Phone: 0300 123 6780
Email: developeras@lancashire.gov.uk
Your ref: 3/2025/0564
3/2025/0565
Our ref: 3/2025/0564/HDC/KW
3/2025/0565/HDC/KW
Date: 18 December 2025

Location: 45 - 47 Whalley Road, Clitheroe, BB7 1EE
Proposal: Planning permission for proposed change of use from light industrial to residential (use class C3) and commercial (use class E(c)(iii)) involving internal and external alterations.
Grid Ref: 374236 441280

Summary

No objection subject to conditions

PL01

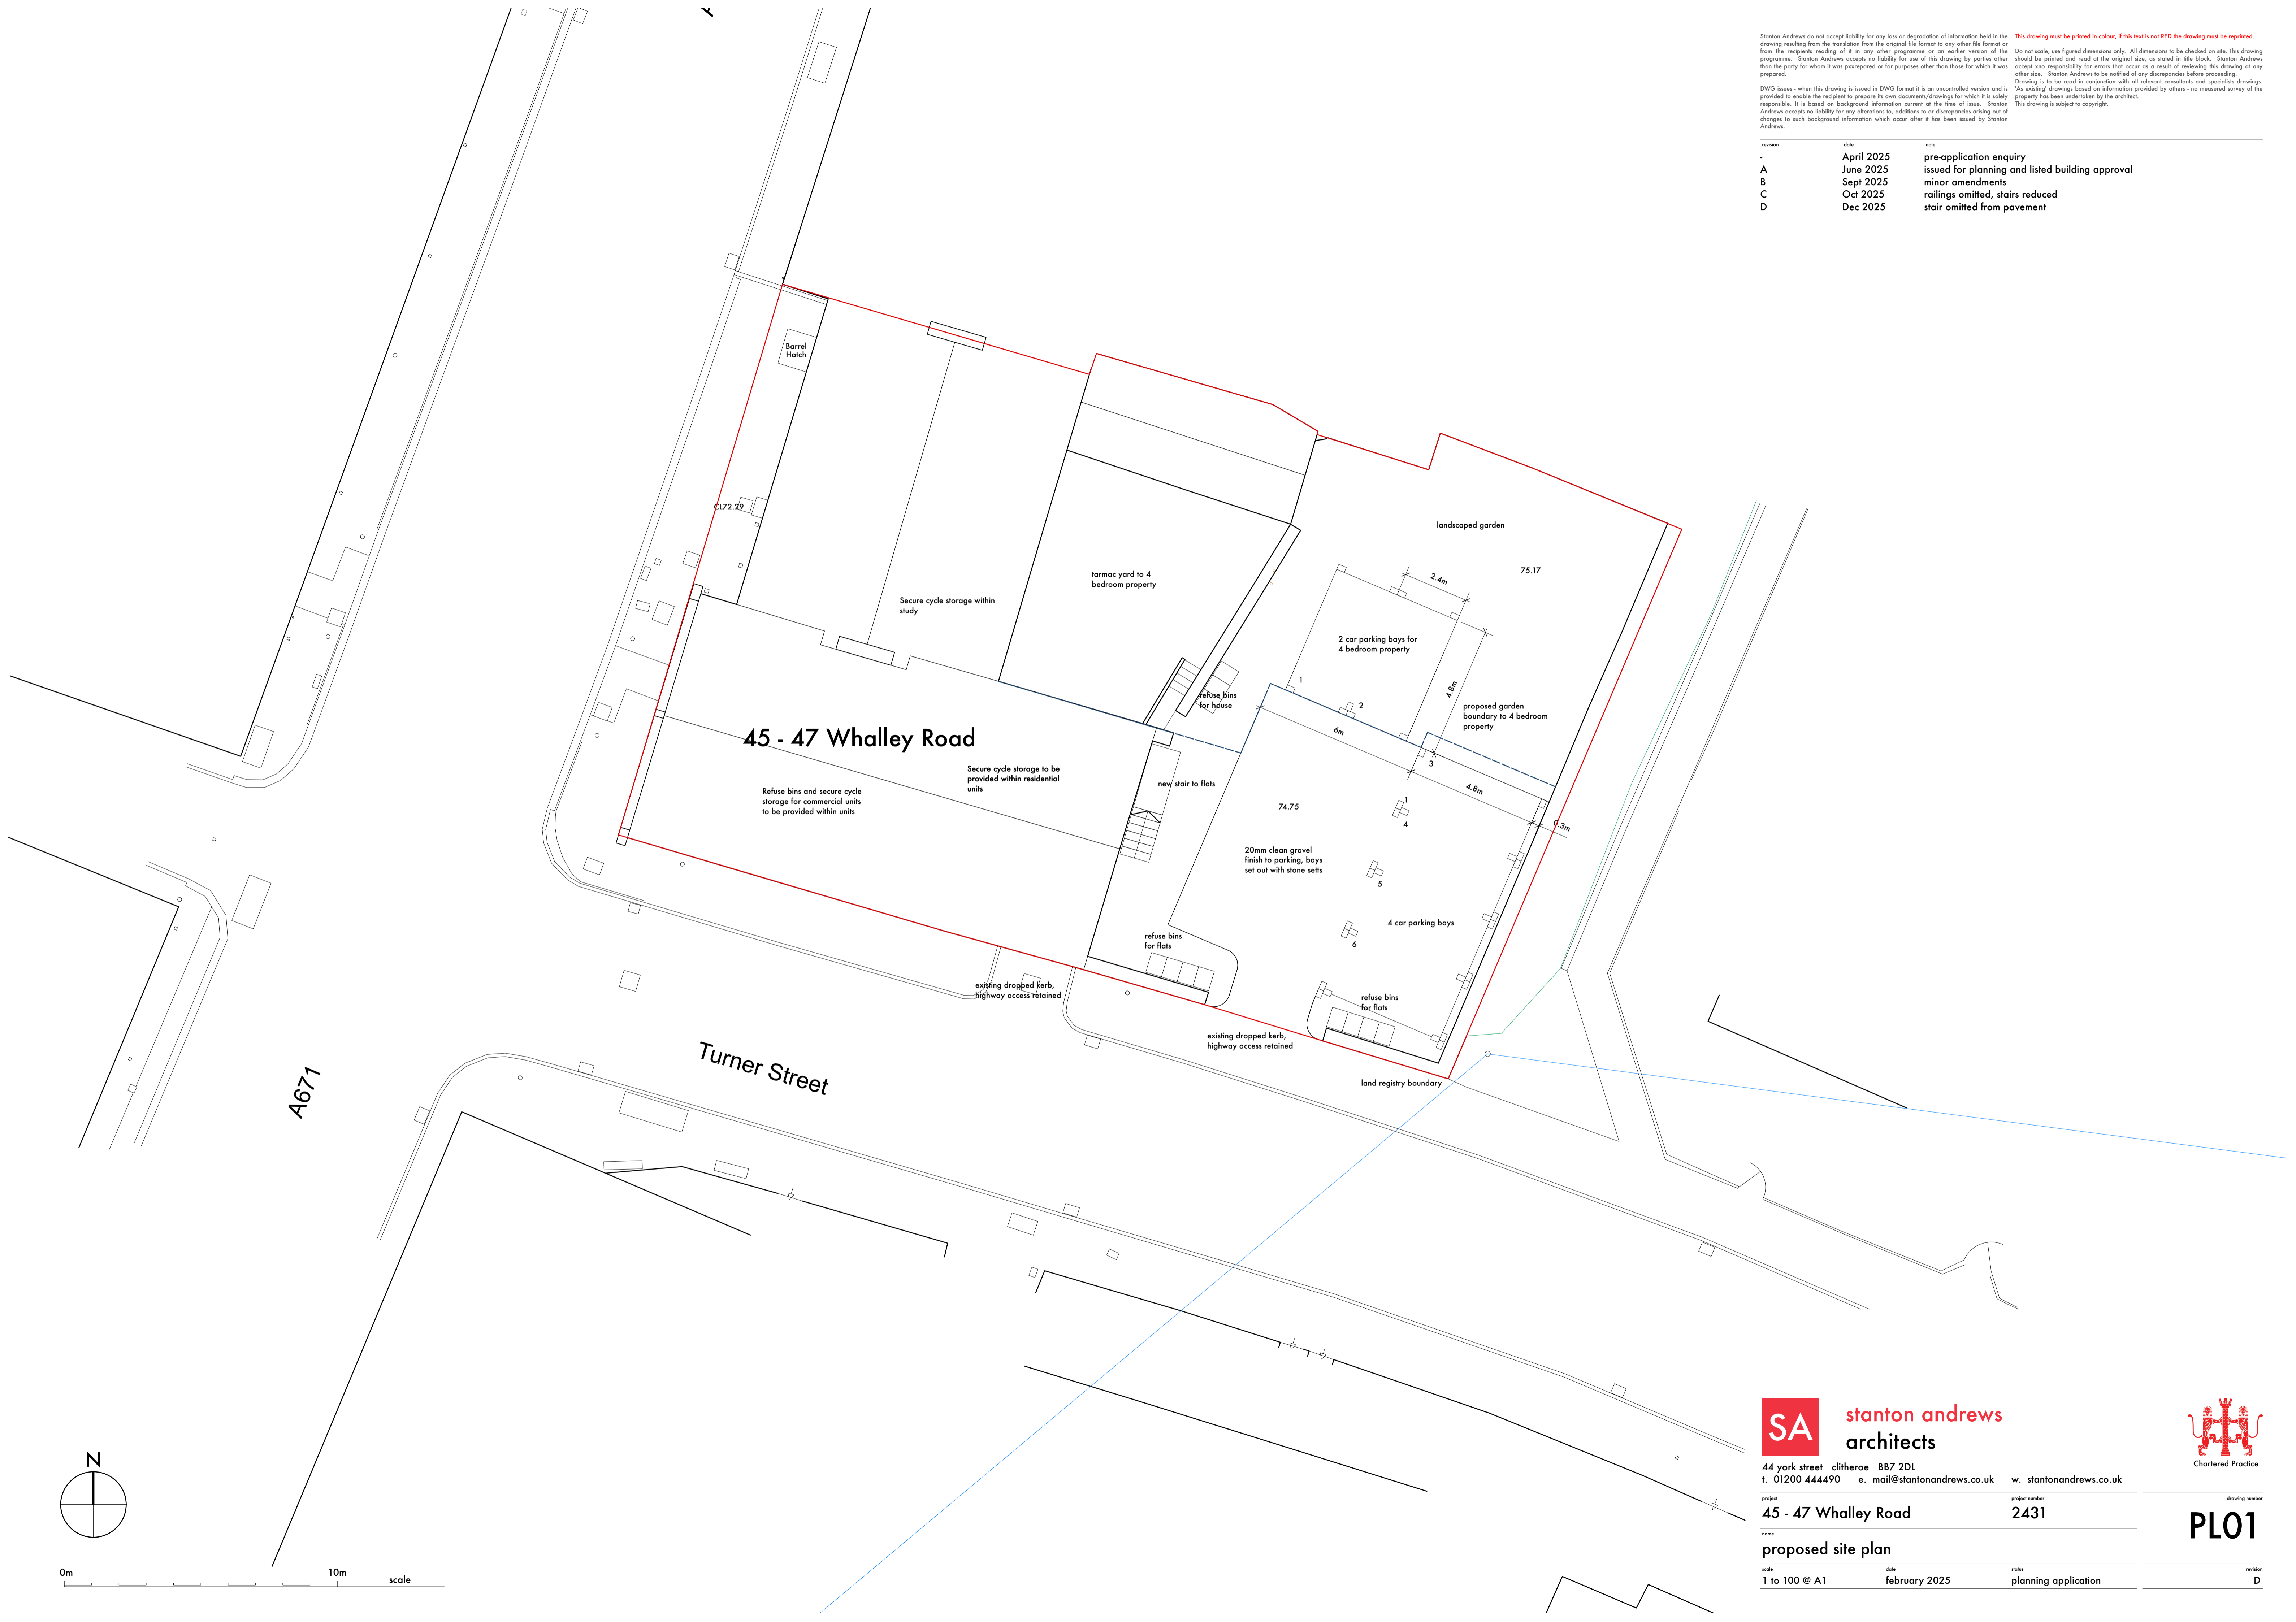
The site will be accessed via an existing vehicle access on Turner Street, an unclassified road with a 20 mph speed limit fronting the site. The applicant has provided an amended plan which shows that the existing gates and any proposed gates are to be removed. The access must be properly consolidated and surfaced in bound porous materials (not loose stone, gravel or grasscrete) for the first 5m into the site to prevent debris from being deposited onto the highway.

Further pedestrian access will be provided on Whalley Road, to serve the proposed four-bedroom dwelling. Previously, the LHA raised concerns regarding the positioning of external steps and railings positioned within the adopted highway; these have since been removed and internal steps have been provided within the building.

The LHA has reviewed drawing number PL01 Rev D. Currently, six parking spaces are proposed within the parking area, allocated to the residential element of the development.

Two spaces are designated for the four-bedroom dwelling. The LHA would expect three off-street parking spaces for dwellings with four bedrooms or more. Given the sustainability of the area, situated close to amenities and public transport options, the LHA would accept a shortfall of 1 parking space for the 4 bedroom dwelling and will condition that cycle storage is provided within the site to further encourage and promote sustainable transport.

The site does not provide parking for the commercial units, however there are local public car parks within walking distance to the site which can be utilised for future business owners. The site is located within a sustainable location with good access to public transport and local amenities. There are also parking restrictions on the surrounding roads to control on street parking.

2. The development hereby permitted shall not be occupied or brought into use until the car parking and turning areas shown on the approved plan(s) have been provided in full and are available for use. The car parking and turning areas shall thereafter be kept available for the parking and manoeuvring of vehicles at all times.

5. Before the access is used for vehicular purposes, that part of the access extending from the highway boundary for a minimum distance of 5m into the site shall be appropriately paved in tarmacadam, concrete, block pavements, or other hard material to be approved by the Local Planning Authority.
